HIGHWAYS REPRESENTATION

OBJECTION

Planning Reference:	23/01165/FUL
Location:	Pilot House, Embankment Road, Bembridge, PO35 5NR
Proposal:	Demolition of dwelling & commercial building; proposed replacement dwelling (C3 (a) Dwellinghouses) & 19no. industrial units (B2 General industrial & B8 (storage or Distribution))
Road Status:	B Classified Road, publicly maintainable highway Marine Way, unadopted private road
Date of Site Visit:	26 July 2023
Date of Report:	1 August 2023
Planning Case Officer:	Maria Bishop

BLOCK PLAN

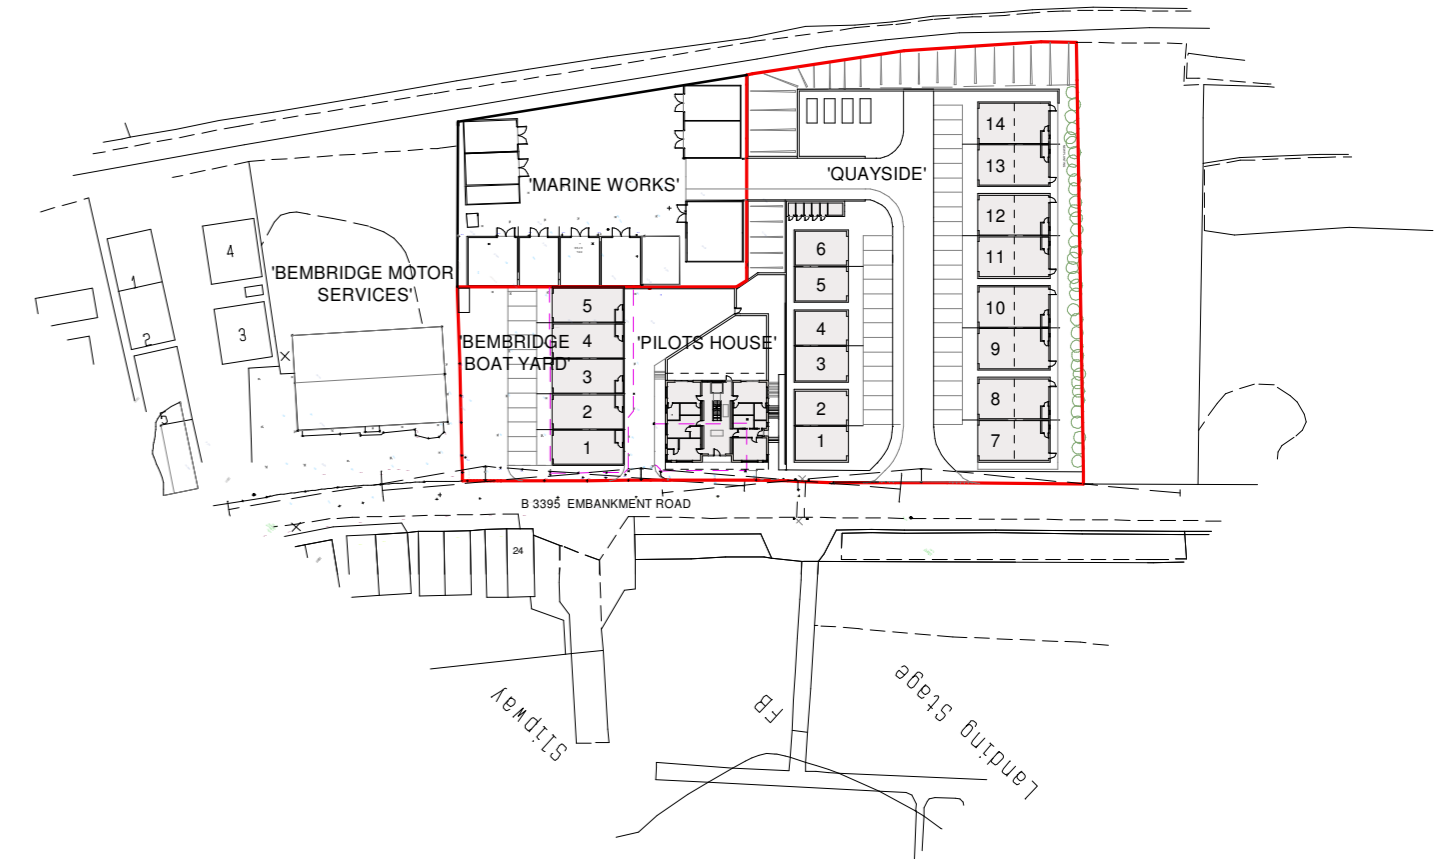
In respect of the access into Marine Way, the required visibility sight line distance (Y) when measured from a point 2.4m(X) back from the edge of carriageway at a height of 1.05m, central to the access and to the near kerb line (kerb on development side) between the heights of 0.6m and 2.0m above the carriageway has been shown to be achievable within the Applicant's land to the north east but limited to around 27m to the south west.

In respect of the access to the proposed units 1 to 5 adjacent to Bembridge Motor Services, the required visibility sight line distance (Y) when measured from a point 2.4m(X) back from the edge of carriageway at a height of 1.05m, central to the access and to the near kerb line (kerb on development side) between the heights of 0.6m and 2.0m above the carriageway has been shown to be achievable within the Applicant's land to the south west but limited to around 4m to the north east.

I can confirm that this proposal is, therefore, not in compliance with this standard, in respect of where the visibility splays extend beyond the boundary of the site and onto third party land.

Two of the proposed accesses are unsatisfactory to serve the proposed development by reason of unacceptable visibility and would therefore be contrary to Policy DM2 (Design Quality for New Development) of the Isle of Wight Core Strategy.

More favourable consideration could be given if speed survey on Embankment Road were carried out approximately 60m either side of the site to determine the current 85th percentile wet weather speed of traffic which would enable the use of Table 7.1 of Manual for Streets to establish the relevant Stopping Sight Distances (SSD) and the appropriate Y distance.
